Arun District Council
Arun Civic Centre
Maltravers Road
Littlehampton
West Sussex BN17 5LF
Planning & Building Control General Enquiries
Tel: (01903) 737756 Fax: (01903) 730442
Dx: 57406 Littlehampton
Minicom: 01903 732765
e-mail: planning@arun.gov.uk
website: www.arun.gov.uk/planning

Application No: K/19/20/HH
Site Address: 99 Golden Avenue East Preston BN16 1QT
Description of works: First floor walls of existing dwelling to be finished with Hardie cladding in lieu of existing tile hanging.
First floor and pitched roof added to garage with external staircase to rear.

Thank you for your internet representation made on 23rd July 2020 which has been recorded as no objection with the comments as follows:

Drawing: **EXISTING & PROPOSED - GARAGE**

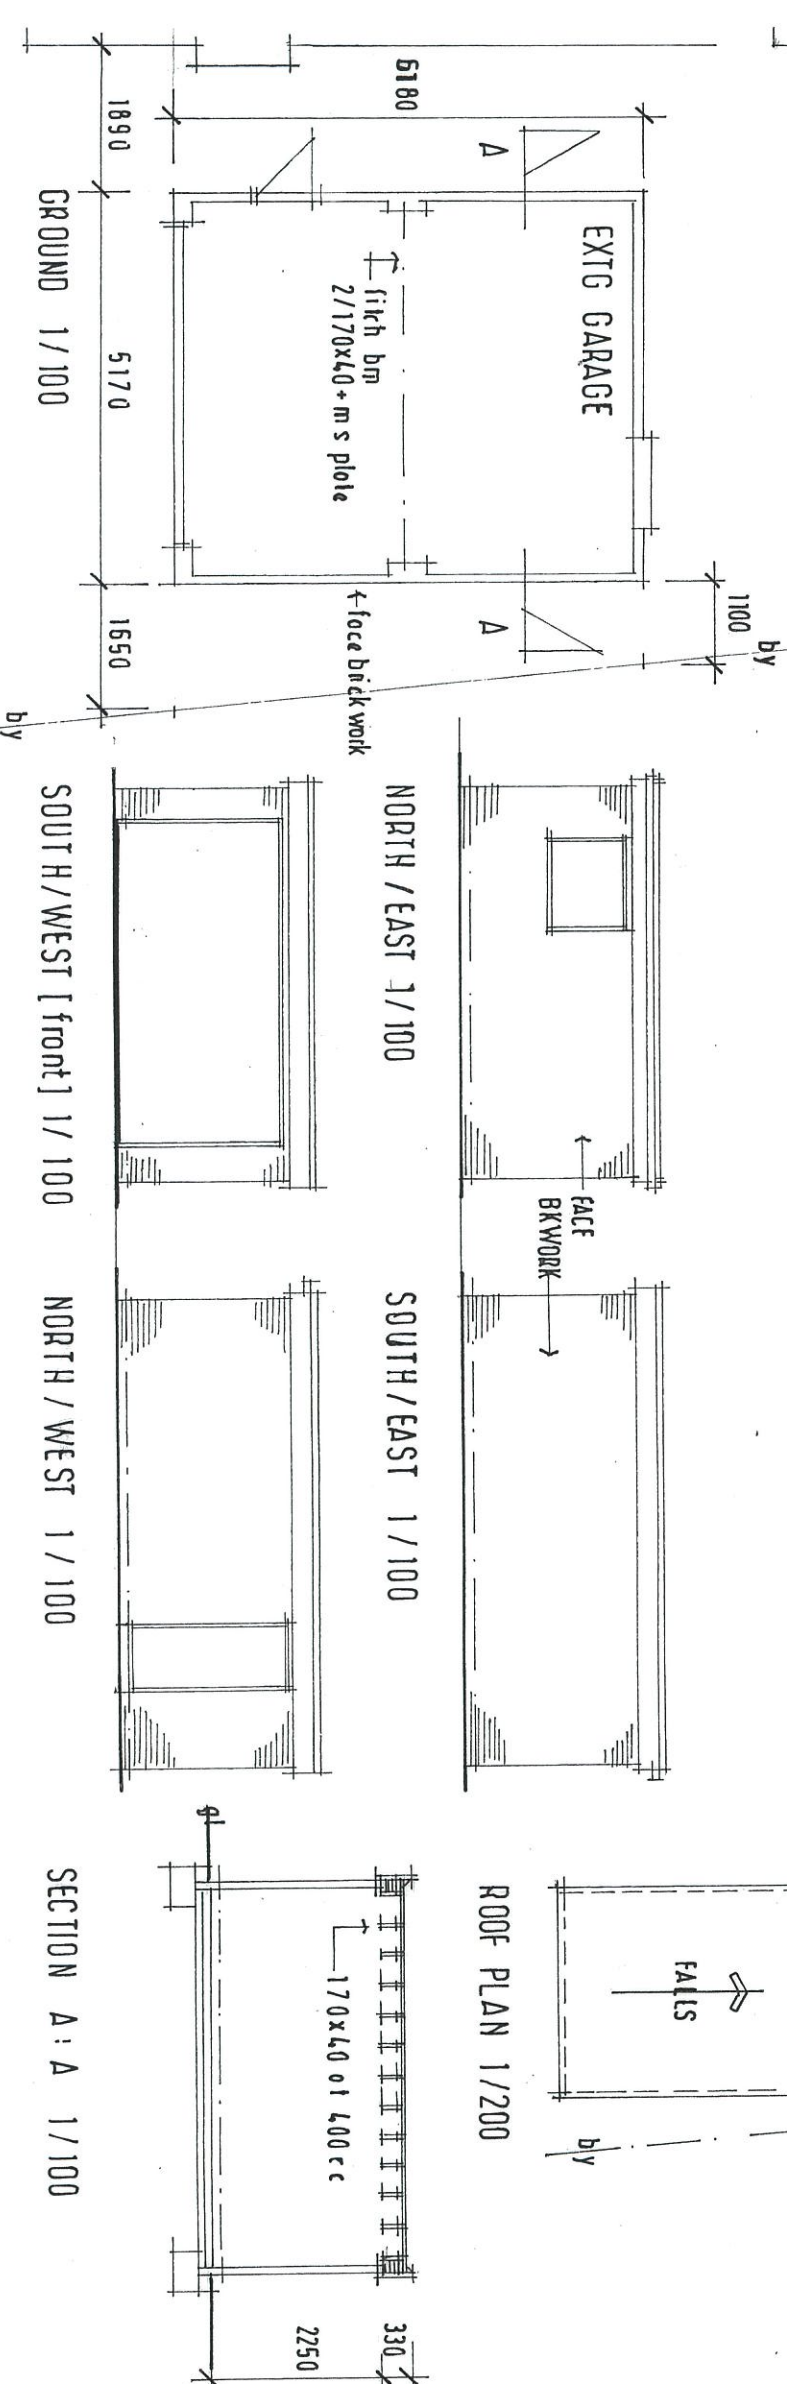
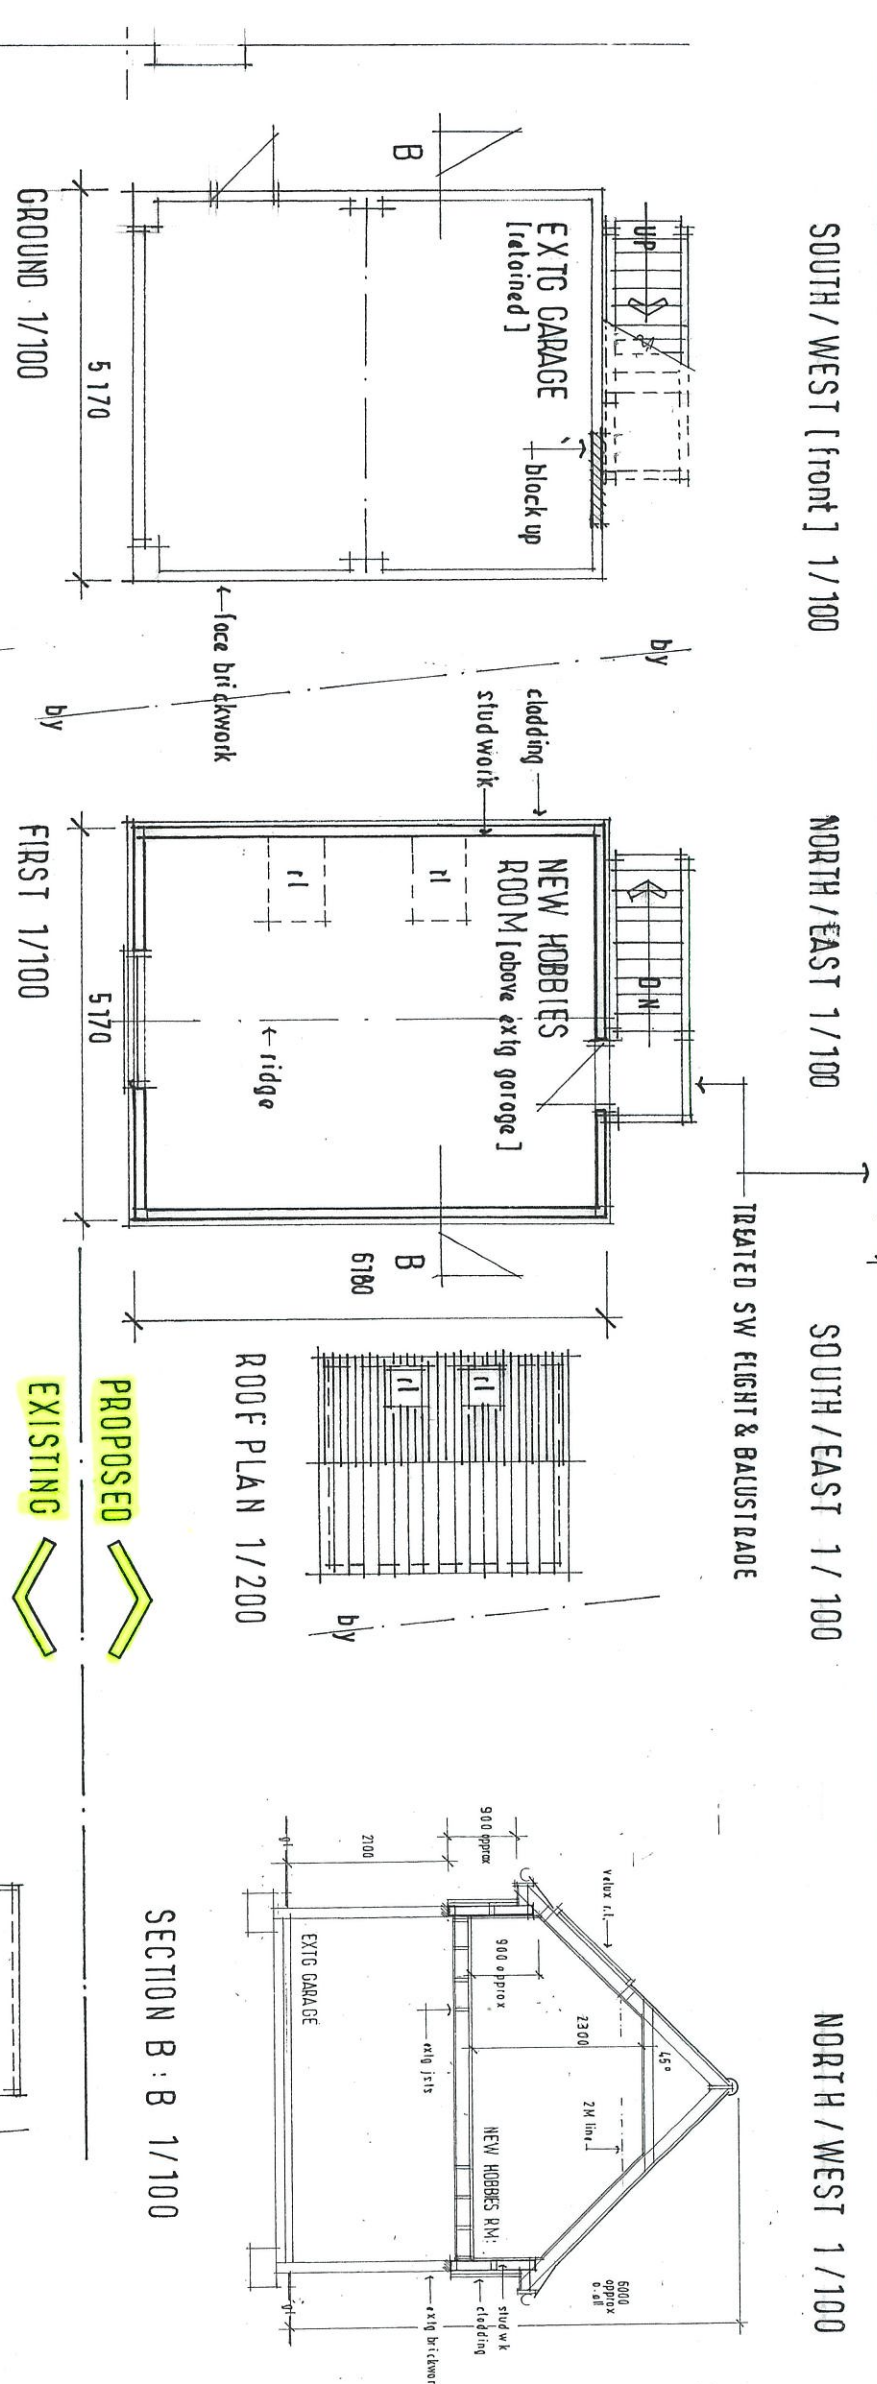
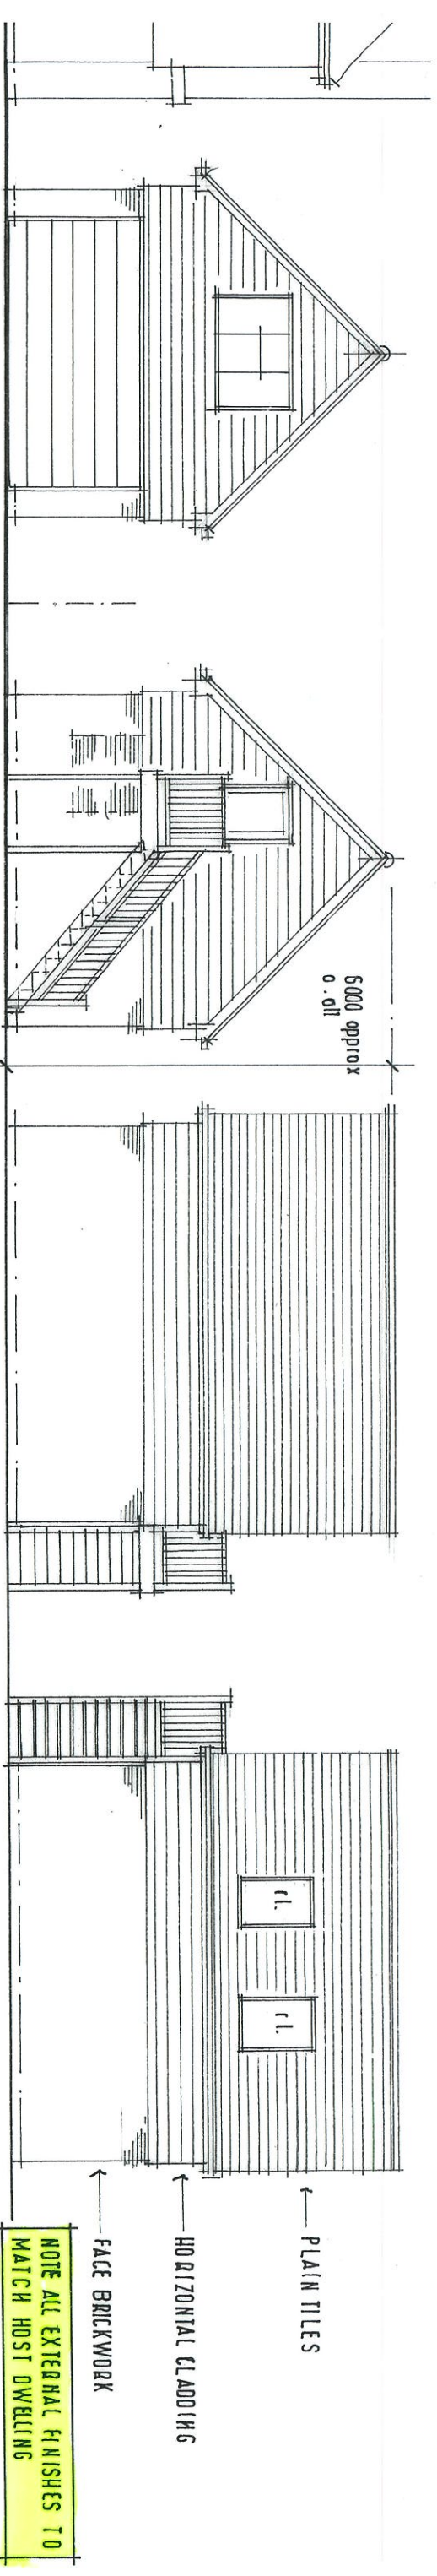
No Objection as long as the case officer is satisfied that:

- the external staircase to the first floor of the garage is not intrusive to the privacy of neighbouring properties
- the proposed increase in size and height to the garage is not out of scale to the main dwelling and does not adversely affect the street scene
